City of Albuquerque Stormwater Construction Site Inspection Report

ESC File No.	B10E003I	Project Name:	Ventana Square Subdivision		
NPDES Id. No.	NMRT004B6	Location:	9600 Universe Blvd		
3/6/2023	Owner	Contractor			
Operator	Diamond Trail Realty, LLC	Franklins - Terminated 8/25/2022			
Contact name & title	Ryan growney				
e-mail	rgrowney@growney-inc.com				
Contact Phone #	850-2427				
COA Inspector	Doug Hughes	Start/End Time:	2pm		
Construction Phase:	infrastructure complete - Seed and hydro mulch on 50% of disturbed site				
Type of Inspection:	Regular	Storm Event	Post Storm Event >0.25"	311/Complaint	Follow Up
Weather at time of inspection?		Clear	Temperature:	~	62
Estimated date of last storm 0.25" or greater		12/3/2022

NPDES POSTING BOARD

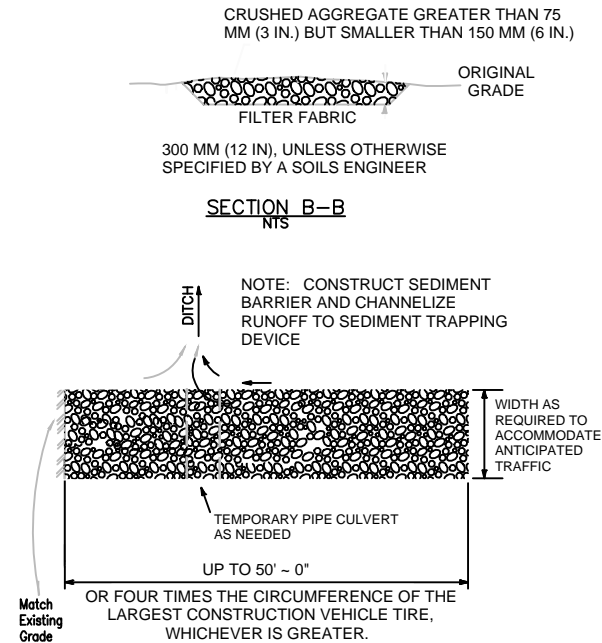
Item Number	Deficiency/ Corrective Action
1	Permit coverage wasn't posted. You must post a sign or other notice of your permit coverage at a safe, publicly accessible location in close proximity to the construction site. The notice must be located so it is visible from the public road that is nearest to the active part of the construction site, and it must use a font large enough to be readily viewed from a public right-of- way per CGP 1.5
2	SWPPP wasn't available on site at time of inspection, so it couldn't be checked to see if it is up-to-date. - Provide a scanned copy of the up-to-date SWPPP with all reports to the Storm Water Quality Section at 600 2nd St NW suite 400 - Jhughes@cabq.gov - Per CGP 4.8.2 after corrective actions are completed and SWPPP is modified with new limits of disturbance, BMPs, and lot sales.
3	BMPs were missing. Silt fence is required around all disturbed areas. c. Corrective actions must begin immediately per CGP2.1.4d. and it must be completed within 7 days then SWPPP modifications must be completed within 7 more days per CGP 5.2. Provide a complete copy of the SWPPP after the Corrective actions, report,s and SWPPP Modification are complete.

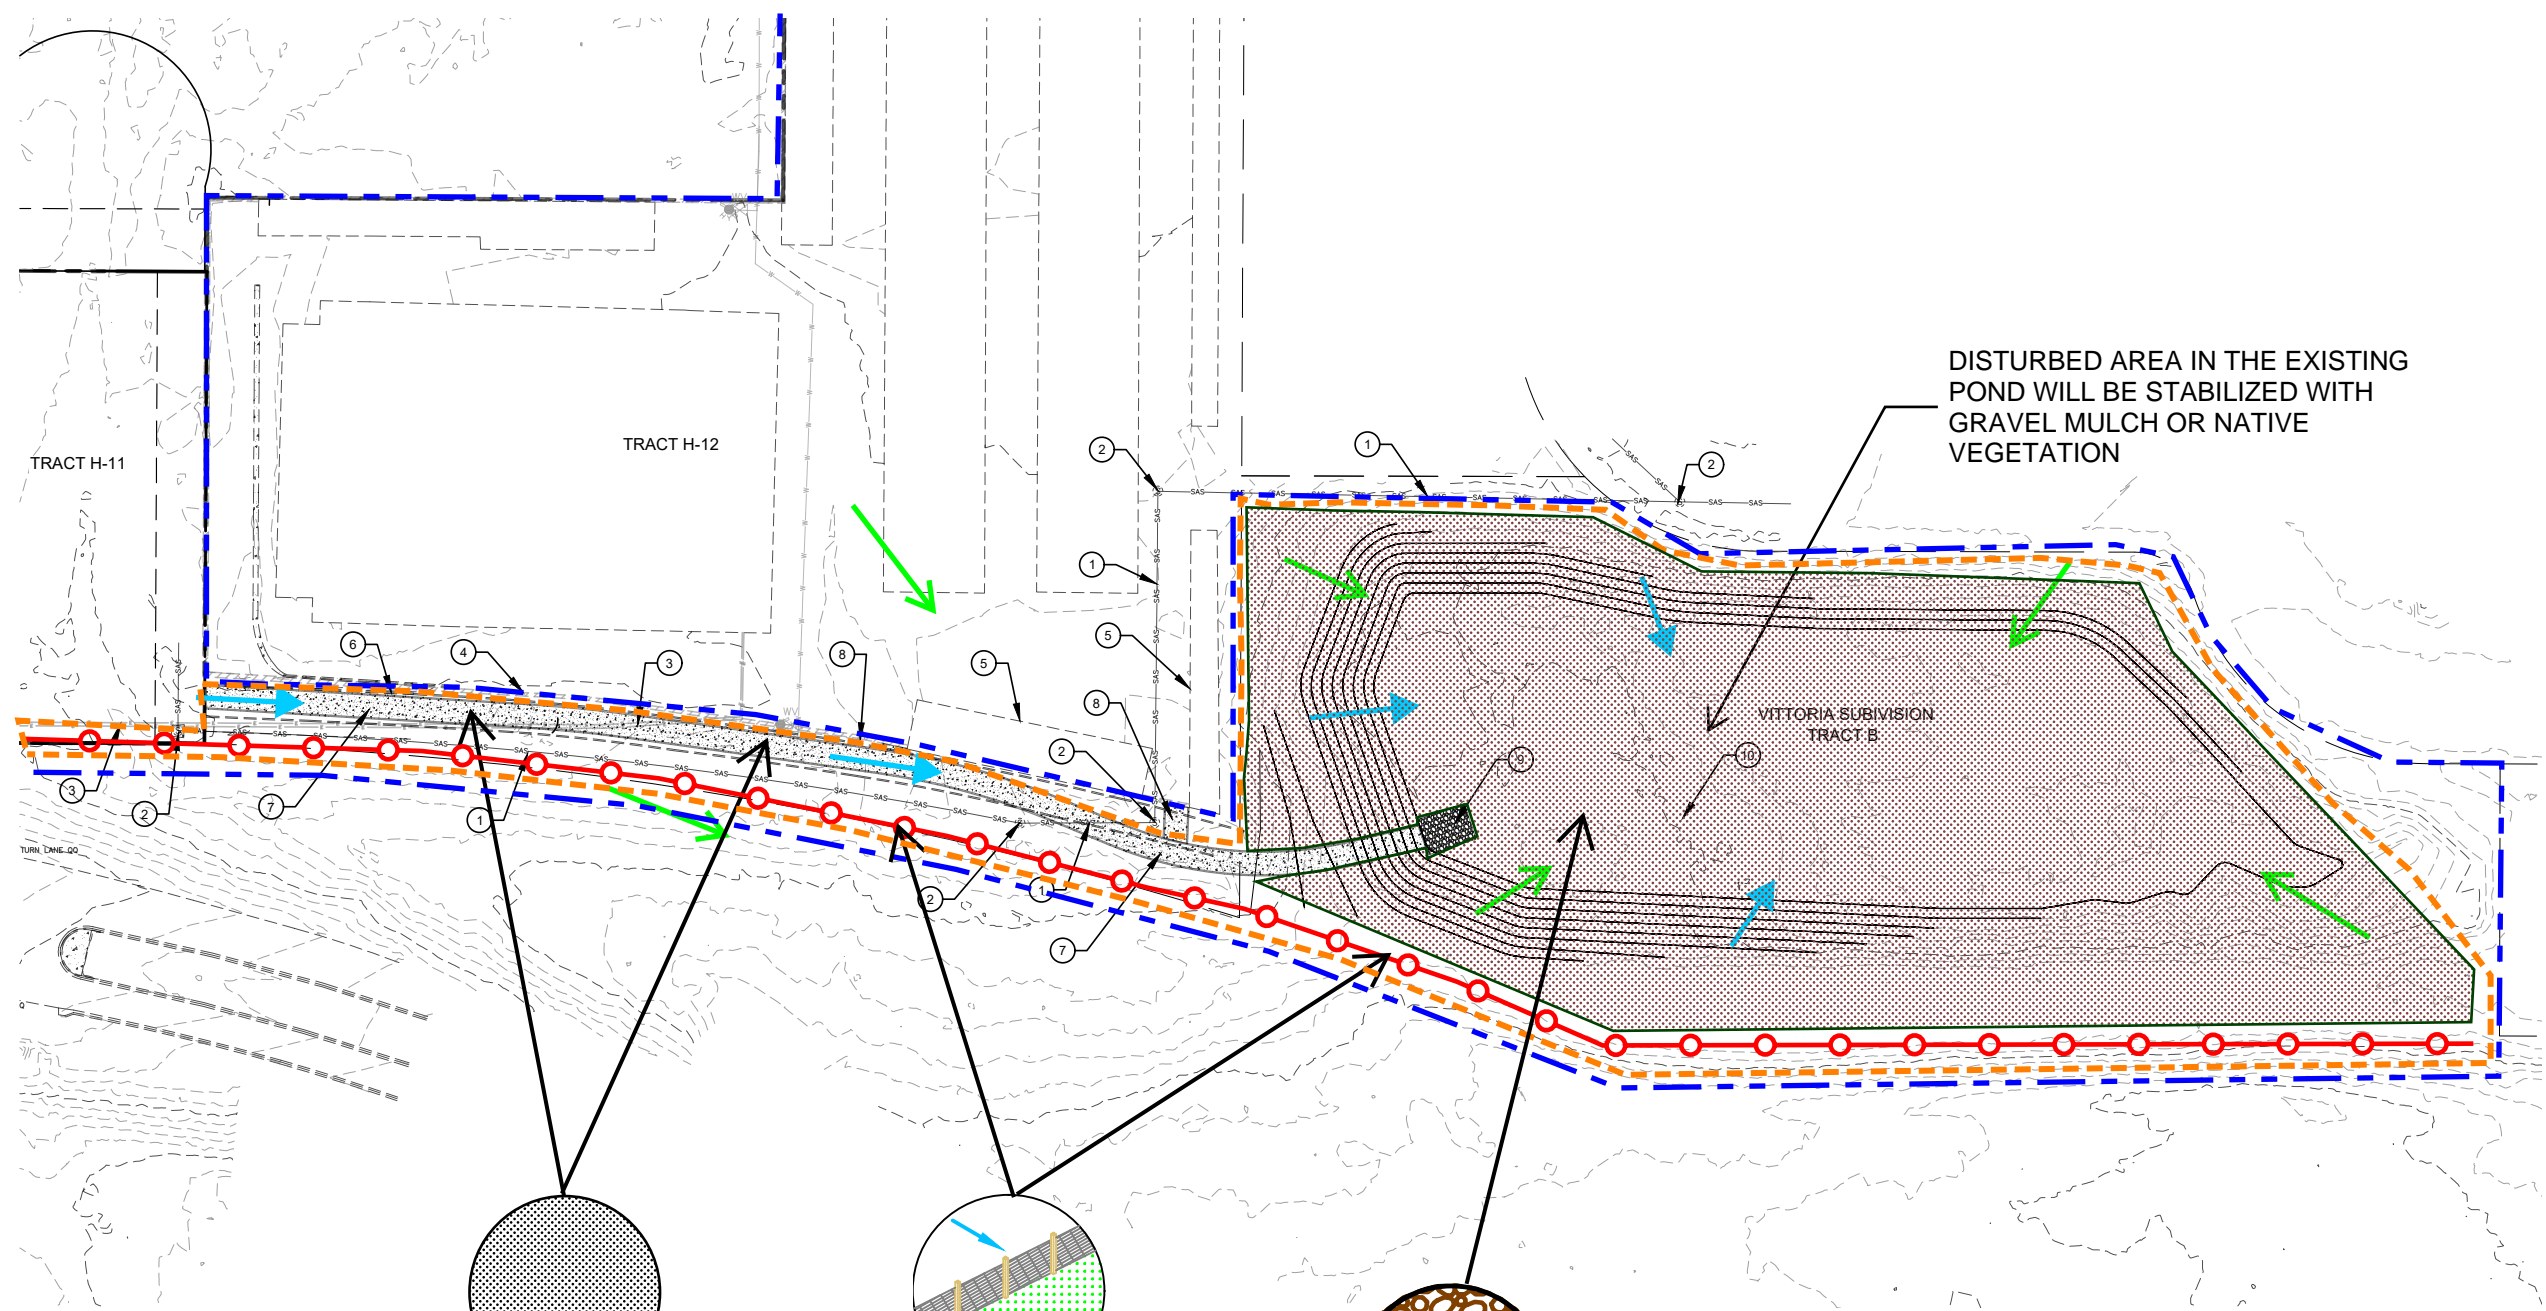
4	Stabilization - seed and Hydromulch is required on all disturbed areas per CGP2.2.14 but it doesn't satisfy the Final Stabelization Criteria of CGP 2.2.14.c until uniform perinnial vegetation is established with no large bare areas. 22. You must continue permit coverage, self-inspections, SWPPP and BMP maintenance until the City determines that the Final Stabilization Criteria CGP2.2.14.c has been satisfied. Then you must remove the BMPs and send documentation of the Final Stabilization to the EPA with a Notice of Termination (NOT) per CGP 8.2 to end your coverage under the CGP. This step is independent of the Work Order. Please copy me with the documentation and the EPA's acceptance of the NOT
5	Concrete washout on Tracts H-5A and H-9A - Remove and dispose contaminated soils and hardened concrete with other waste in per CGP 2.2.3. Direct all future wash water from concrete, paint, and stucco into a leak-proof container per CGP 2.3.4

Tracts H-5A, 6B, 9A, 11 and part of the Paseo Del Norte R/W next to the Channel were disturbed during the infrastructure construction and hydromulched in the late summer of 2022 with no growth yet. The pond has been stabelized with rock. Heavy traffic has destroyed the hydromulch on these tracts east of the current development.
